About the application

Application number: 2025/92234	
What is the application for?:	Variation of condition 2 (plans) on previous permission 2021/92527 for erection
Address of the site or building:	land off, Cockley Hill Lane, Kirkheaton, Huddersfield, HD5 0HH
Postcode:	S9 1XE

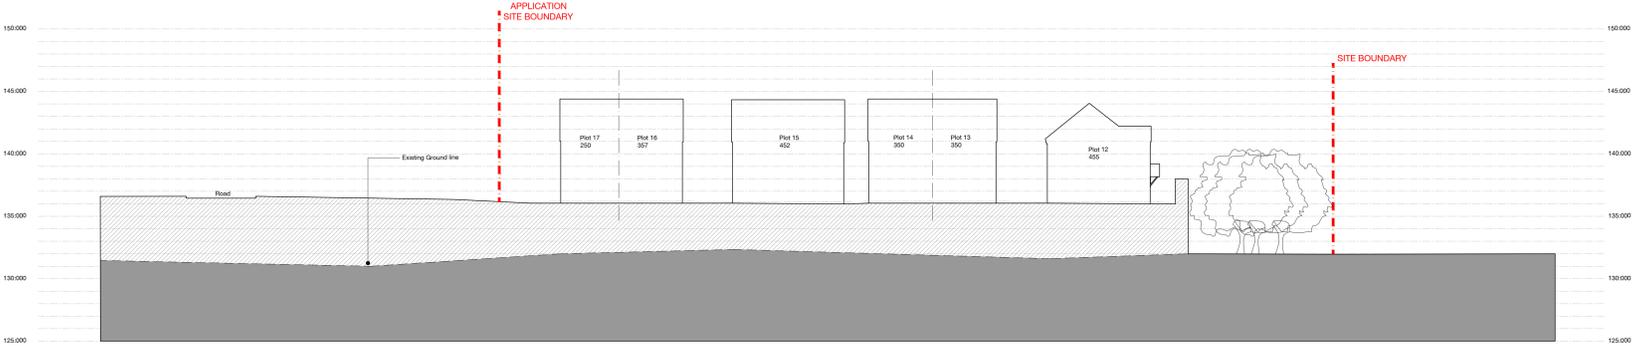
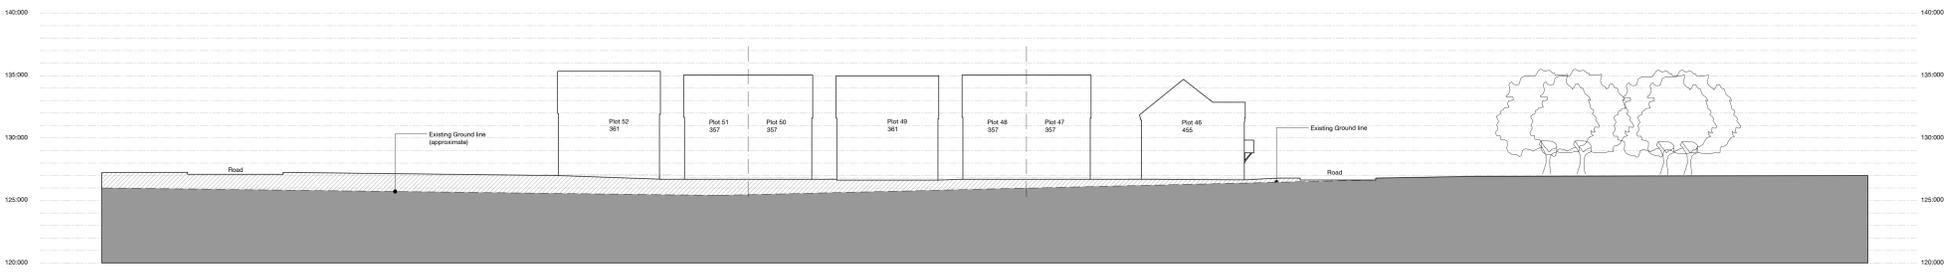
Type of comment: An objection	
Do you wish your comments to be published on the website anonymously?	Yes
I am very concerned at the amount of earthworks right up to the foundations of my house. I would like a promise of compensation or making good if there is any movement or cracking to my house walls.
